SEPA MITIGATED DETERMINATION OF NONSIGNIFICANCE

Project: Cabin Mountain Tree Farm Tracts Large Lot (LL-08-00006) and Cabin Mountain Tracts Large Lot (LL-08-00007)

Description: Adjacent Large Lot subdivision applications, one is to subdivide approximately 154.32 acres into 7 lots and the other is to subdivide approximately 160.56 acres into 8 lots. Both properties are zoned Forest & Range.

CABIN MOUNTAIN TREE FARM TRACTS LARGE LOT SUBDIVISION
 A PORTION OF SECTION 8, TOWNSHIP 20N., RANGE 13E., W.M.
 KITTITAS COUNTY, WASHINGTON

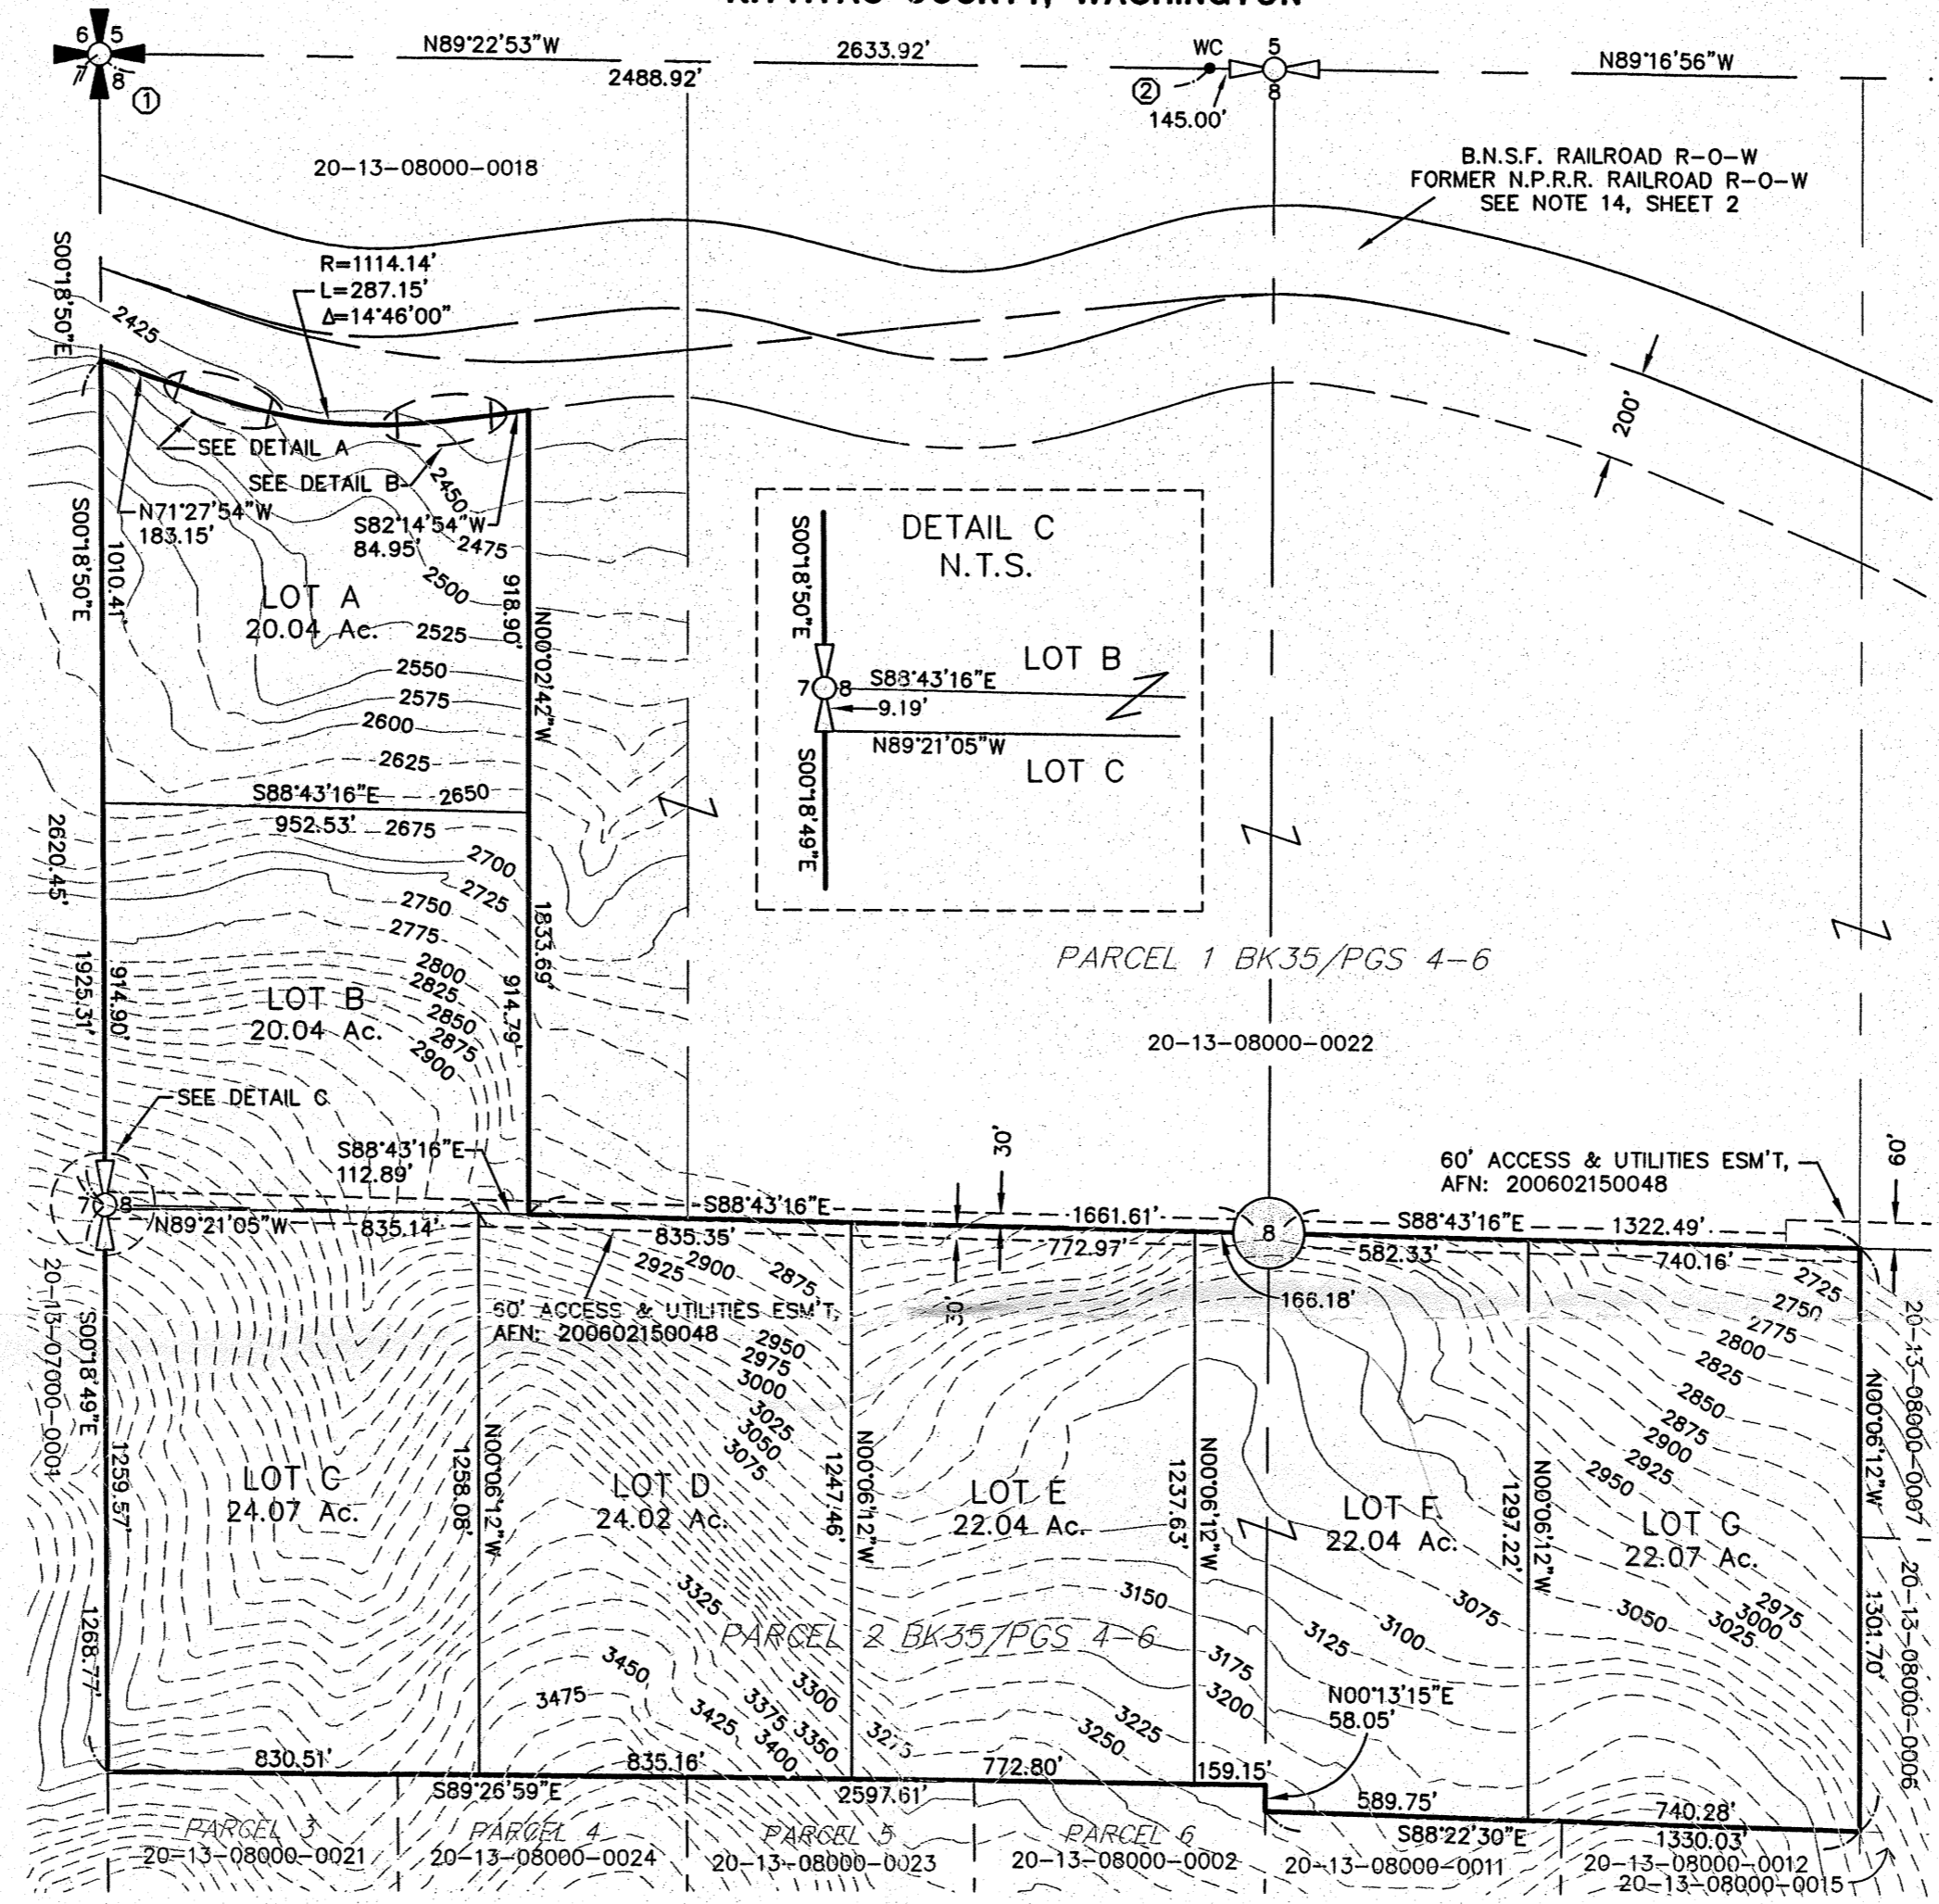
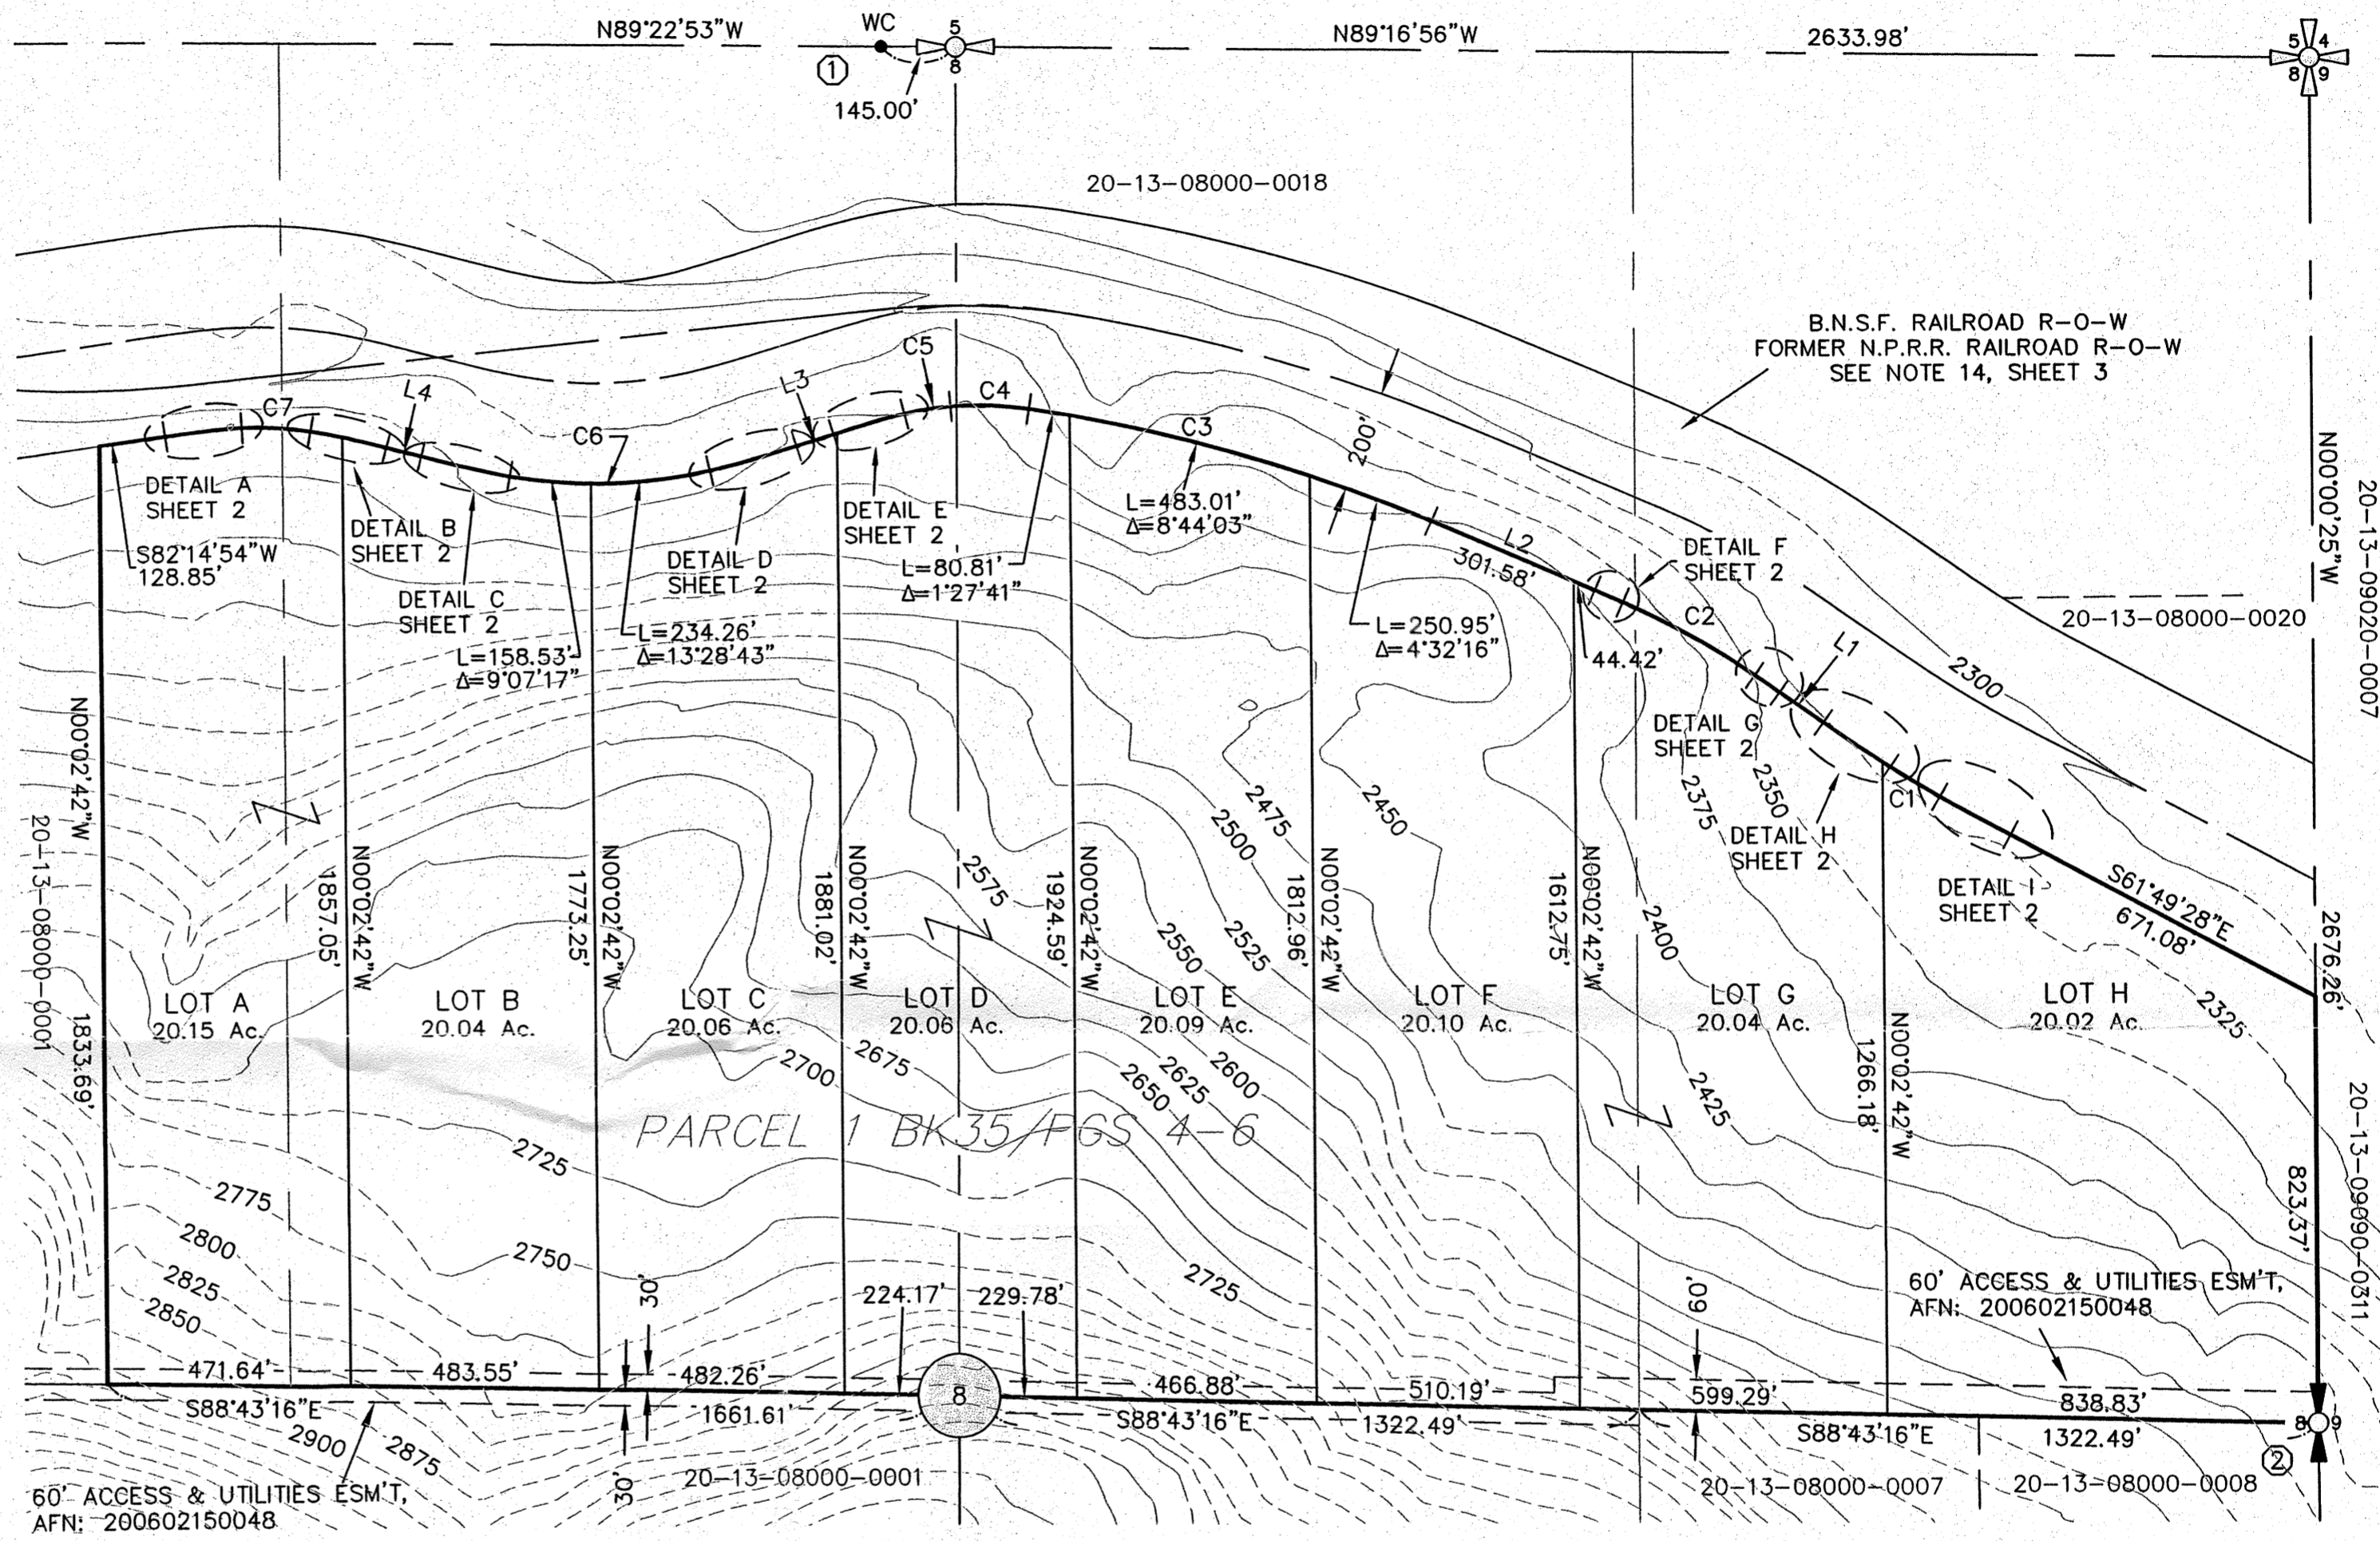
- D. The two projects combined propose 15 lots. The applicant shall eliminate one of the lots prior to submittal of final mylars so that the project does not exceed 14 lots and therefore the project will meet the minimum domestic well requirement of 350 gallons per day (per lot) achieved from their single exemption of 5,000 gallons per day for the entire project (5,000 gpd/ 14 lots = 357 gpl).
